CITY OF ALBUQUERQUE

January 3, 2022

RE: Blue Cross Animal Clinic
1656 University Blvd NE
Grading and Drainage Plan
Engineer's Stamp Date: 11/14/2021
Hydrology File: H15D015B

C101

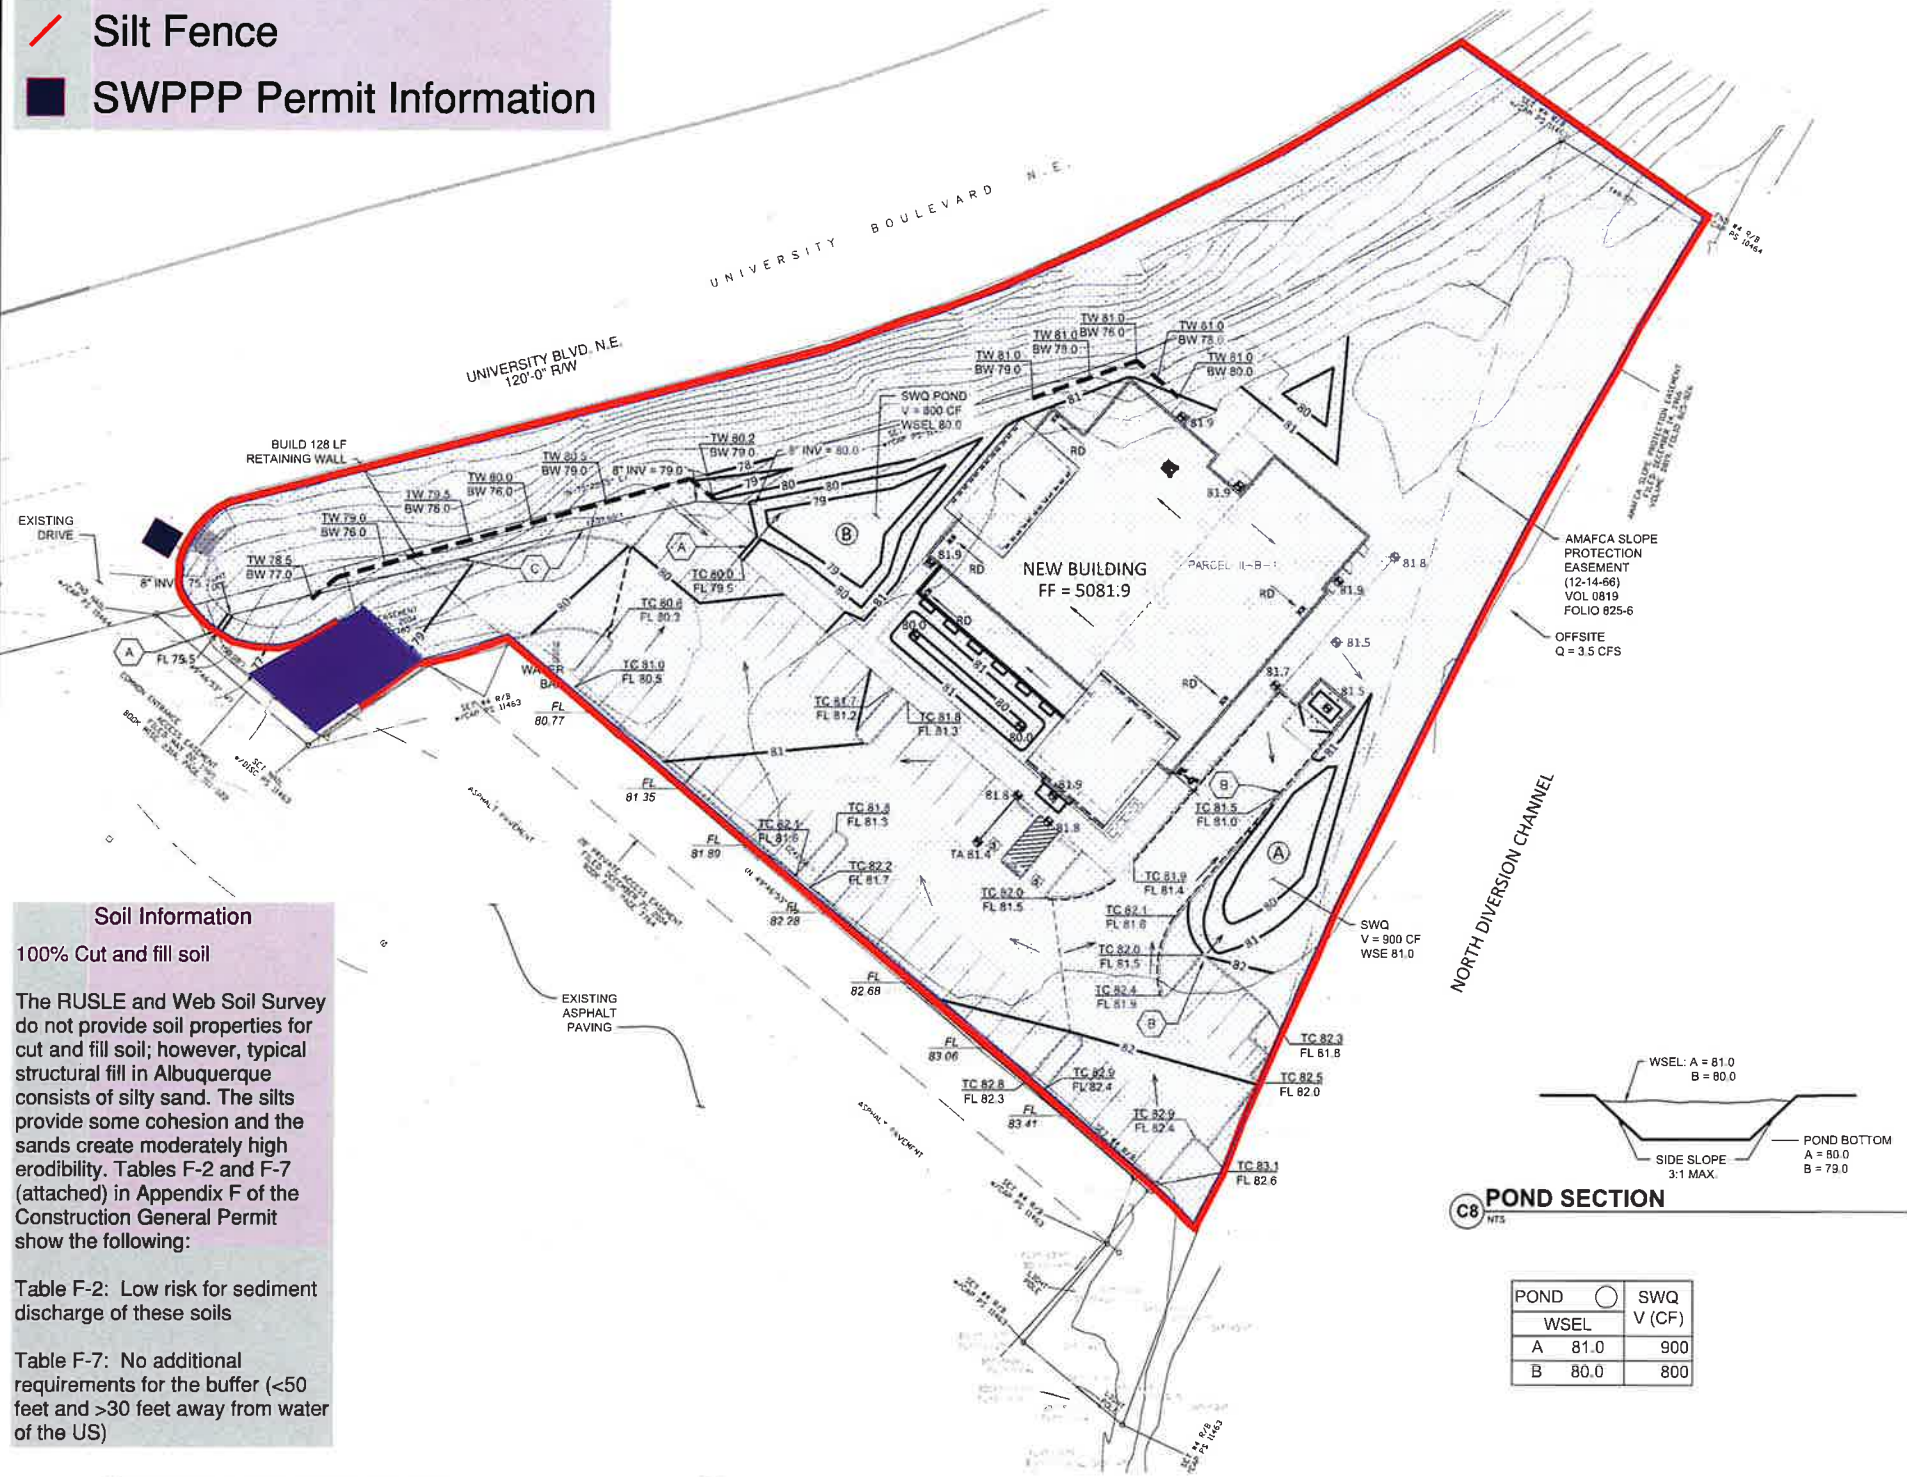
- a.
2. Please clearly show what is proposed vs. existing, label properties, include line types in the legend, and please provide existing spot elevations from survey.

3. Label all ponds and volumes and include sections with all water elevations for storms defined by the DPM.
4. Does this site fall under the classification to require the dumpster to drain into the sanitary system?
5. Please define where offsite flow is coming from? There is no property to the east just the North Diversion Channel.
6. Please label the channel and show it on the plans. Please also reference easements associated with the channel (AMAFCA and include recording info).
7. Ensure you are utilizing new DPM for design. I do not see where your numbers match anything from recent DPM.
8. Provide a water block per standard detail 2426 at entrance. The shown grades do not show how it works with adjacent grades and seems it may all be flowing out the drive. Please clean this up to clarify.

9. Show how each pond will discharge into University Blvd. Is there any containment of the pond? How is it going to be treated? Slopes etc...
10. Please add a note under Grading Notes. "Side slopes need to be stabilized with Native Grass Seed (per City Spec 1012) with Aggregate Mulch or equal (Must satisfy the "Final Stabilization criteria" CGP 2.2.14.b.)".
